Comment for planning application 21/03350/TEL

Application Number	21/03350/TEL
Location	Street Record Station Road Kirtlington
Proposal	Proposed 5G Telecommunications Installation
Case Officer	John Cosgrove

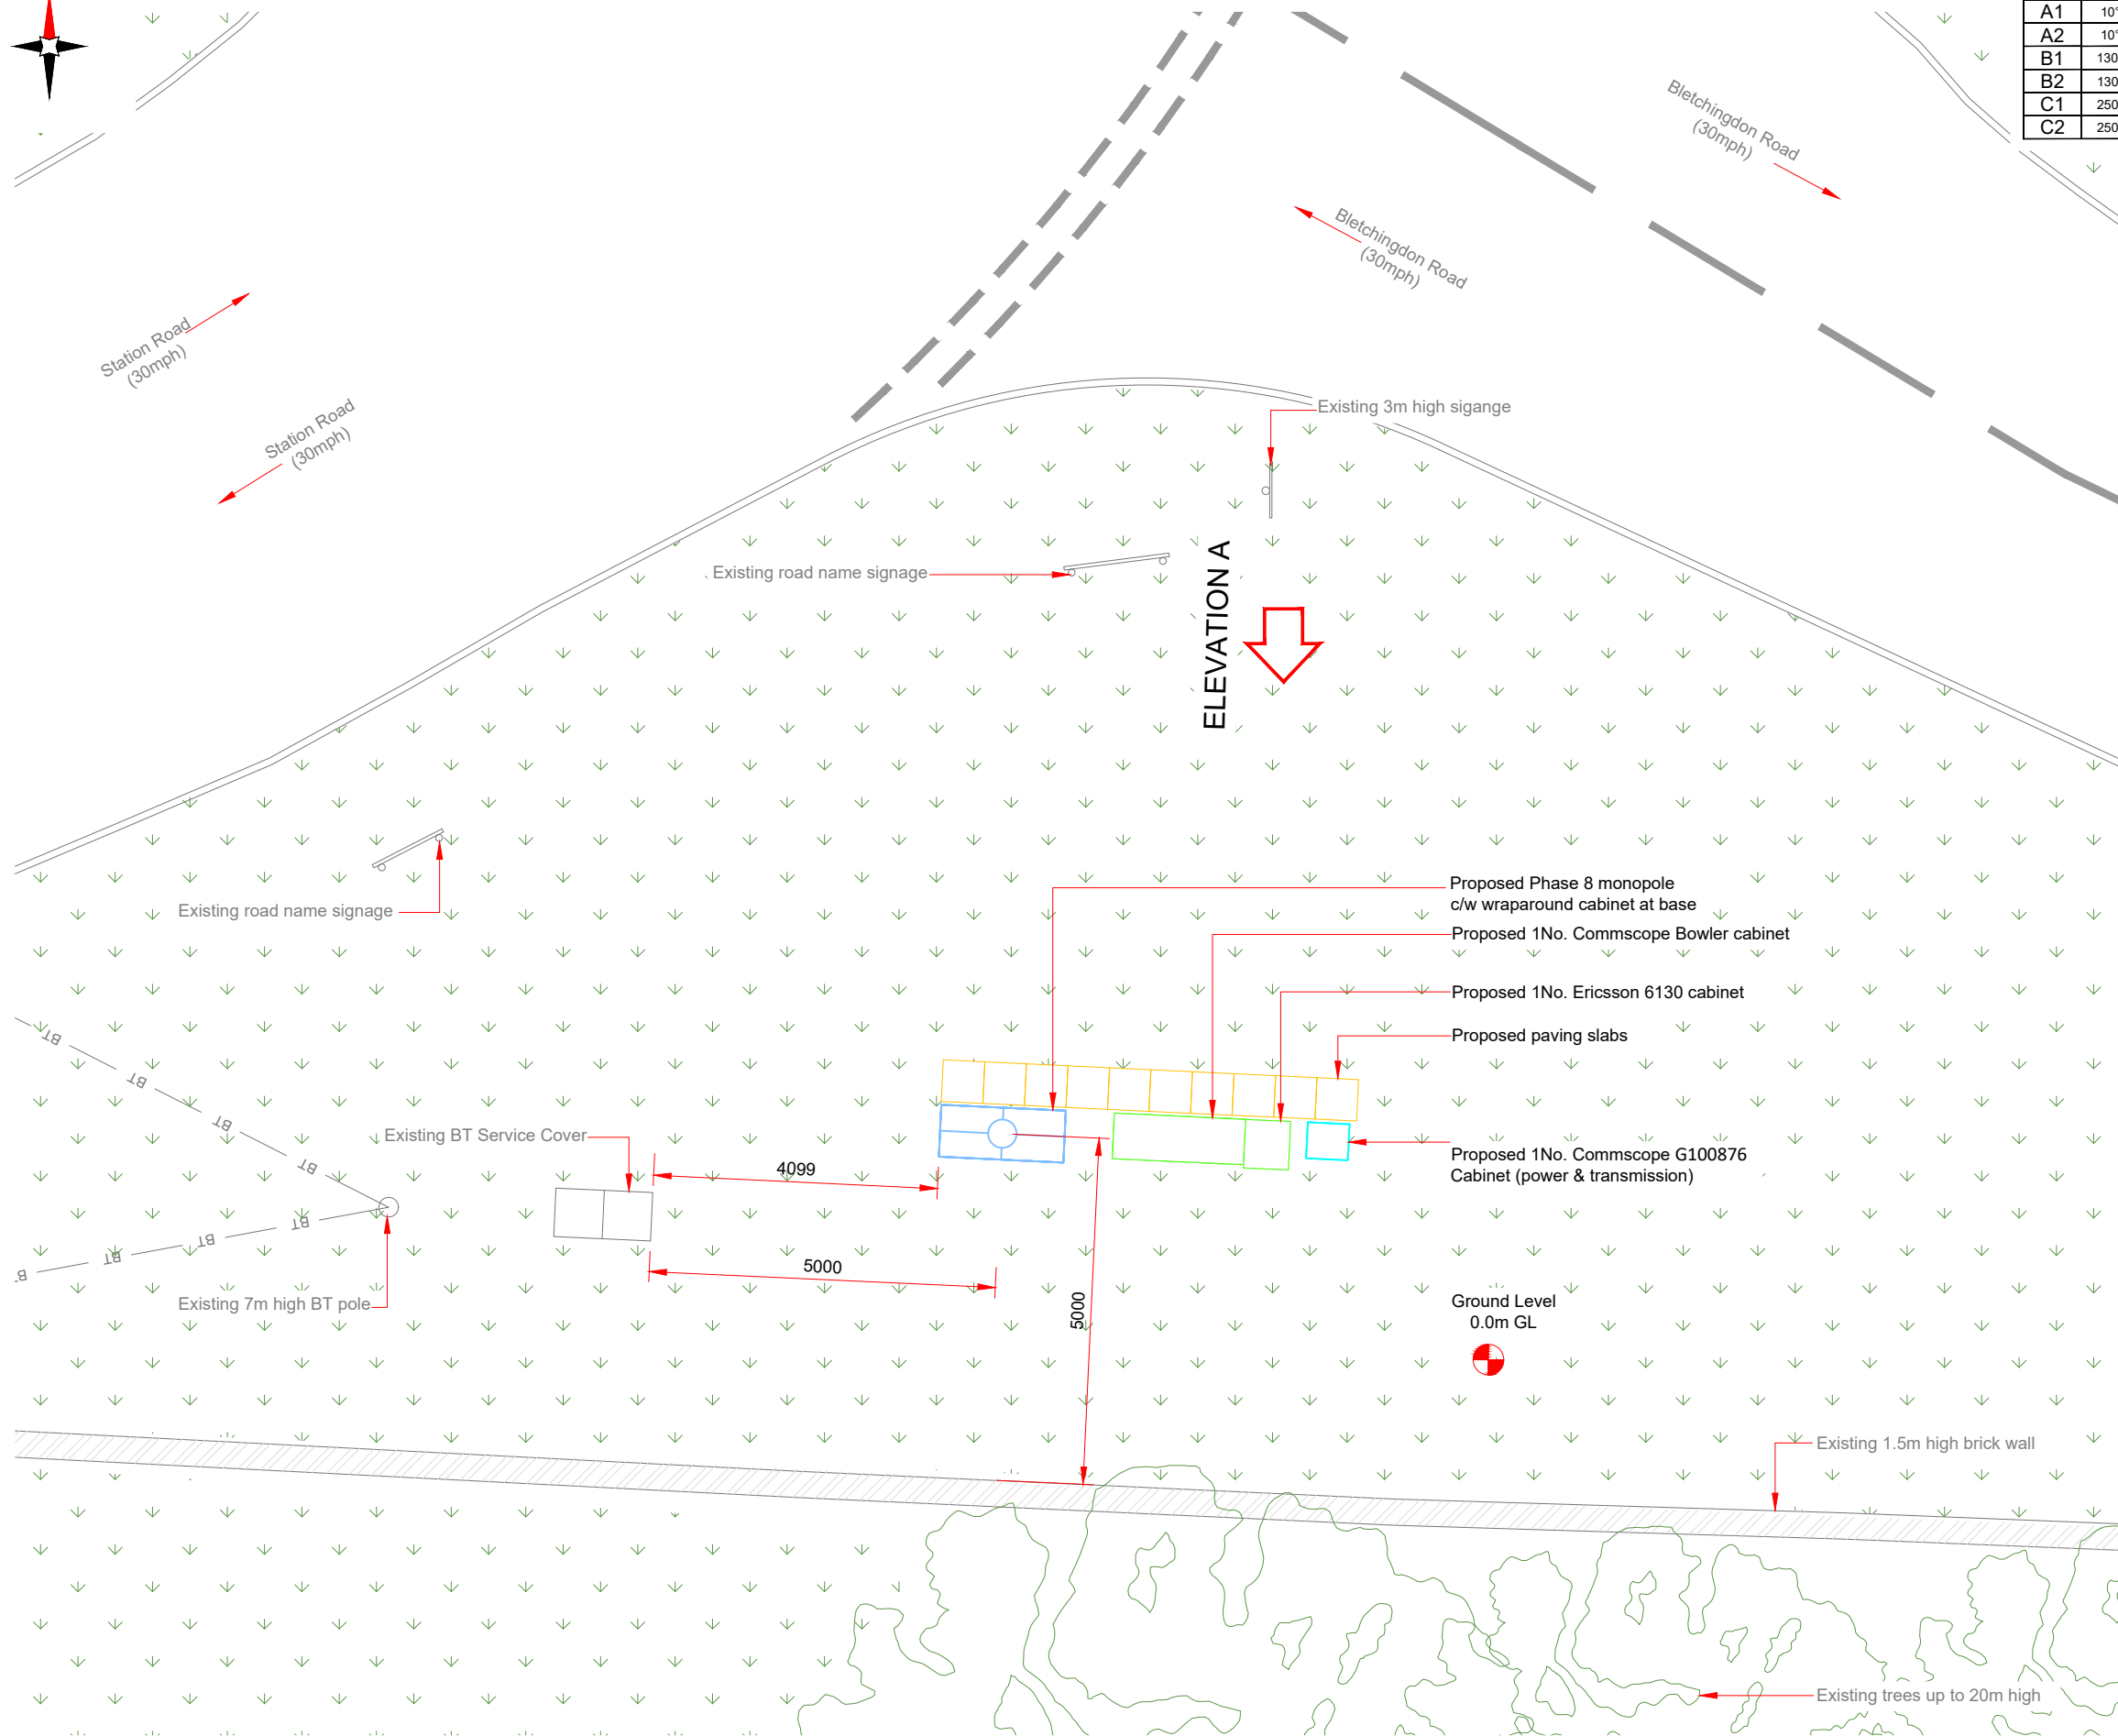
misleading nature of this planning application, in its plan drawings (of existing and proposed) including lack of details both in what the mast will look like bar a misleading drawing against a non-existent tree, and photography that shows very little of the actual area - including NONE of the surrounding houses who will be in direct line of the mast. The half term objection deadline is also very inconvenient to those who want to object. The very fact no one knew about it or was contacted officially suggests the proposers are trying to get it through under radar. Overall I fully object to the above planning application.
